COMMUNITY SERVICES DEPARTMENT

July 1, 2021

Subject: Mayberry Phase 1 PUDSP 219

The Planning Division of the Community Services Department has reviewed the development application for Mayberry Phase I PUDSP and is providing the following final comments on behalf of El Paso County Parks.

HIGHWAY 94
(STATE HIGHWAY - ROW WAIVER)

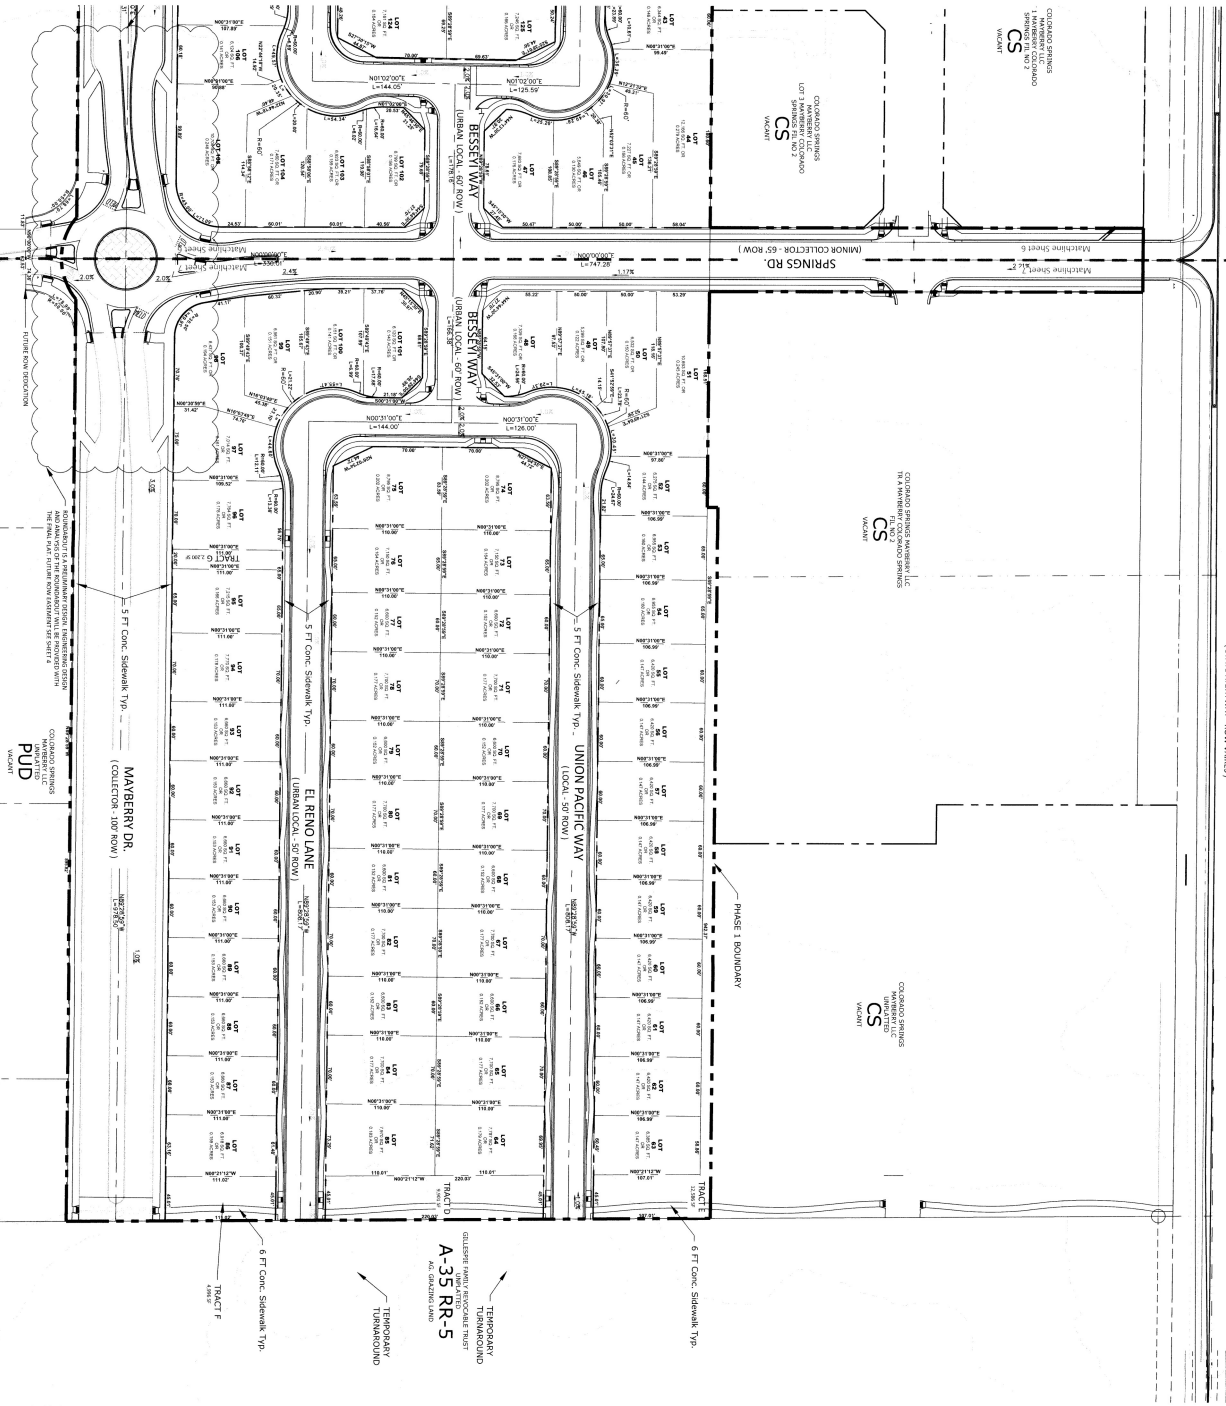
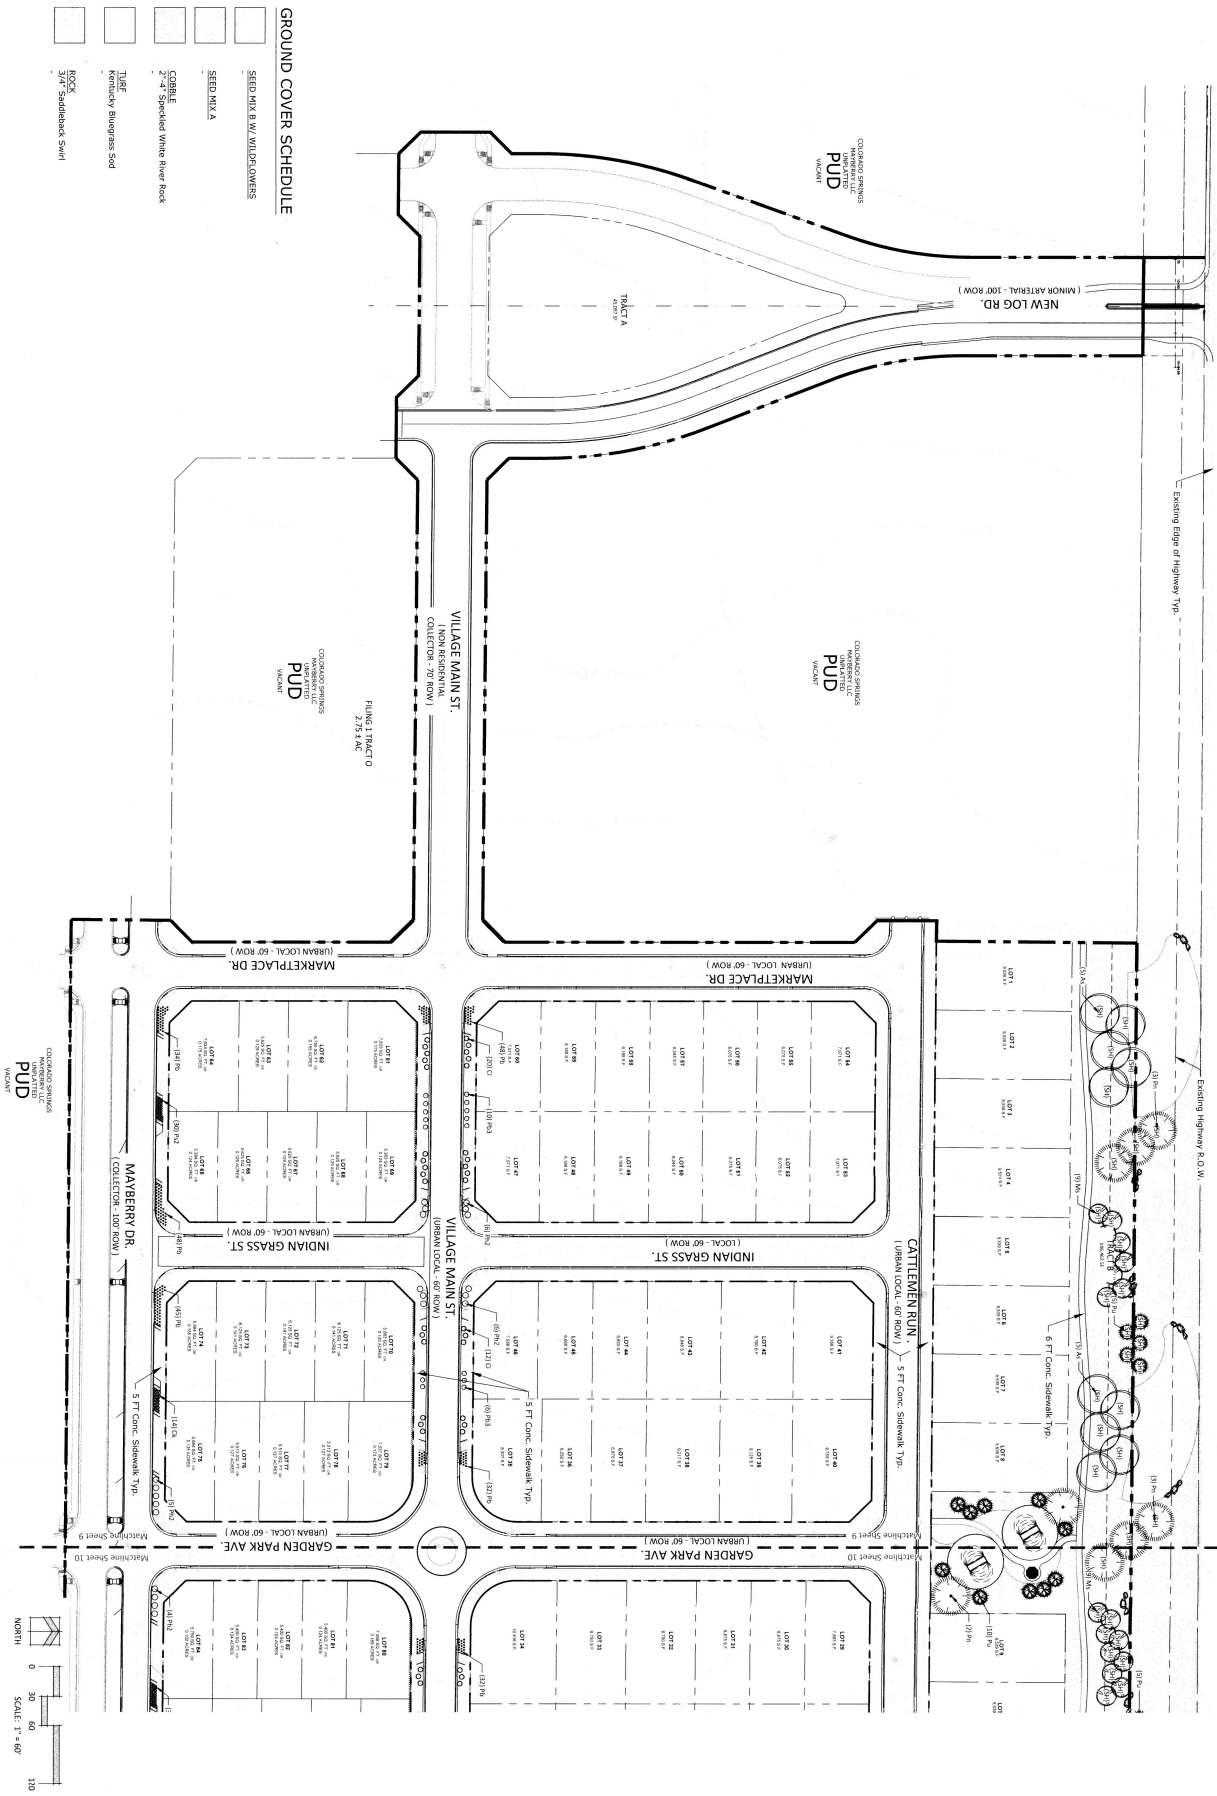
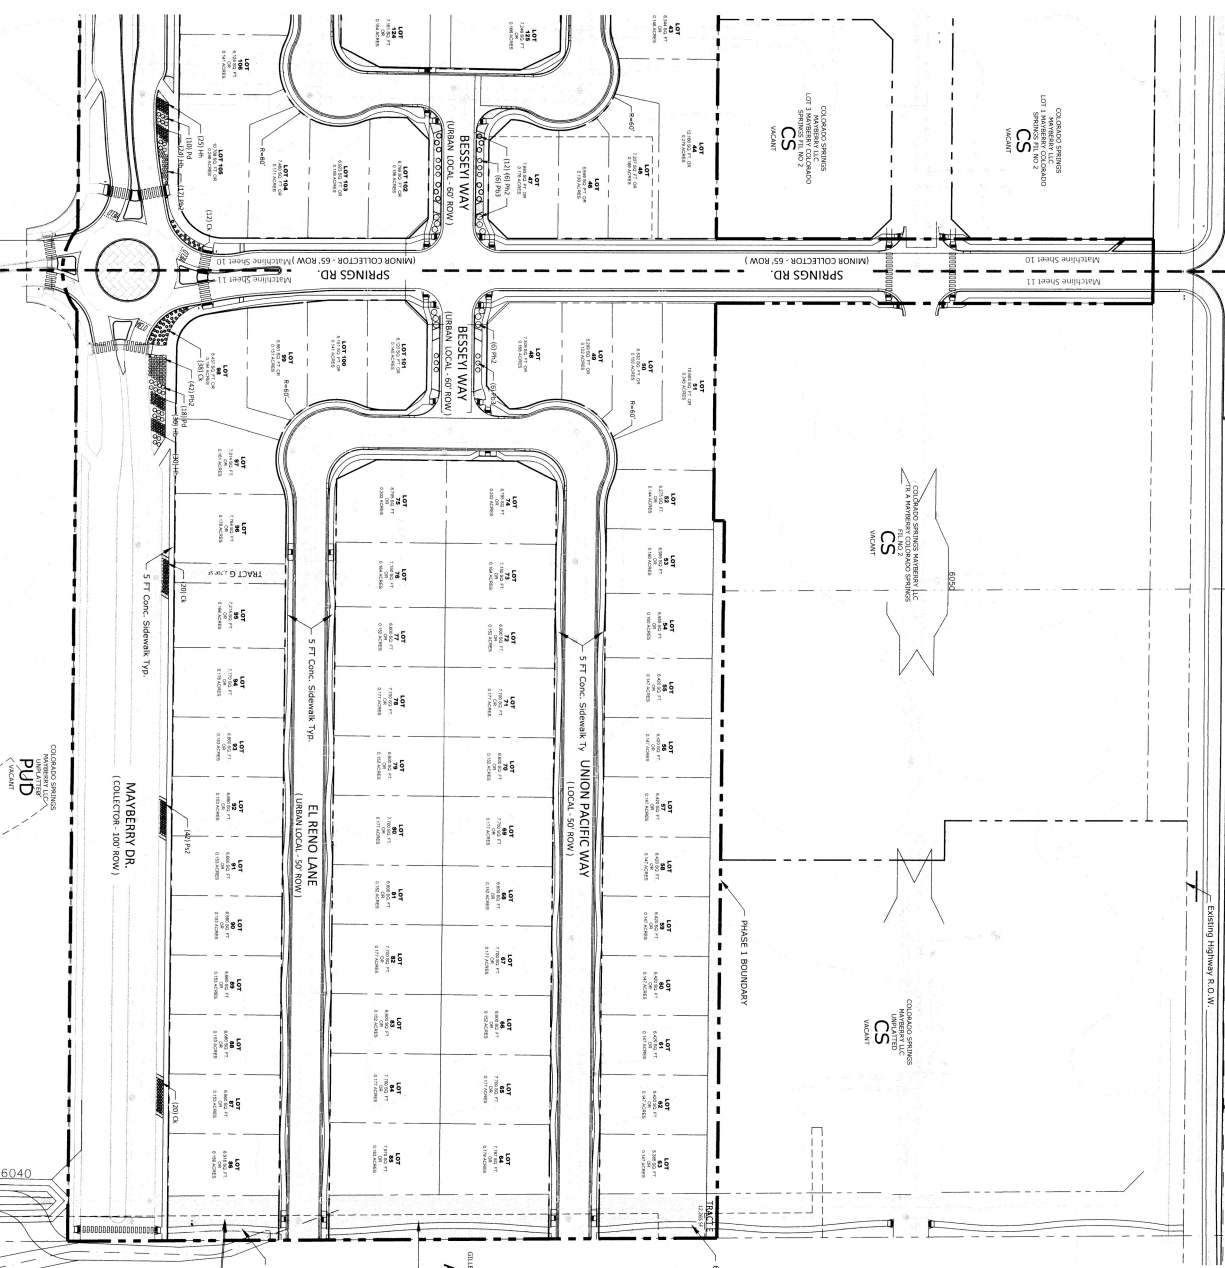
County Parks requests trail easements where development projects impact proposed County trails. As it pertains to this application, the County requests that the landowner provide a 25-foot public trail easement along the south side of Highway 94 that allows for the construction and maintenance by El Paso County of a Secondary Regional Trail, and this easement shall be shown and dedicated to El Paso County on the Final Plat.

Recommend that the Planning Commission and the Board of County Commissioners include the following conditions when considering and/or approving the Mayberry Phase I PUD Final Plat: (1) fees in lieu of land dedication for urban park purposes in the amount of \$69,600 and regional park fees in the amount of \$110,400 will be required at time of the recording of this Final Plat. A Park Lands Agreement may be an acceptable alternative to urban park fees, provided the agreement is approved by the County and executed prior to recording of this Final Plat. (2) provide a 25-foot public trail easement along the south side of Highway 94 that allows for the construction and maintenance by El Paso County of a Secondary Regional Trail, and this easement shall be shown and dedicated to El Paso County on the Final Plat.
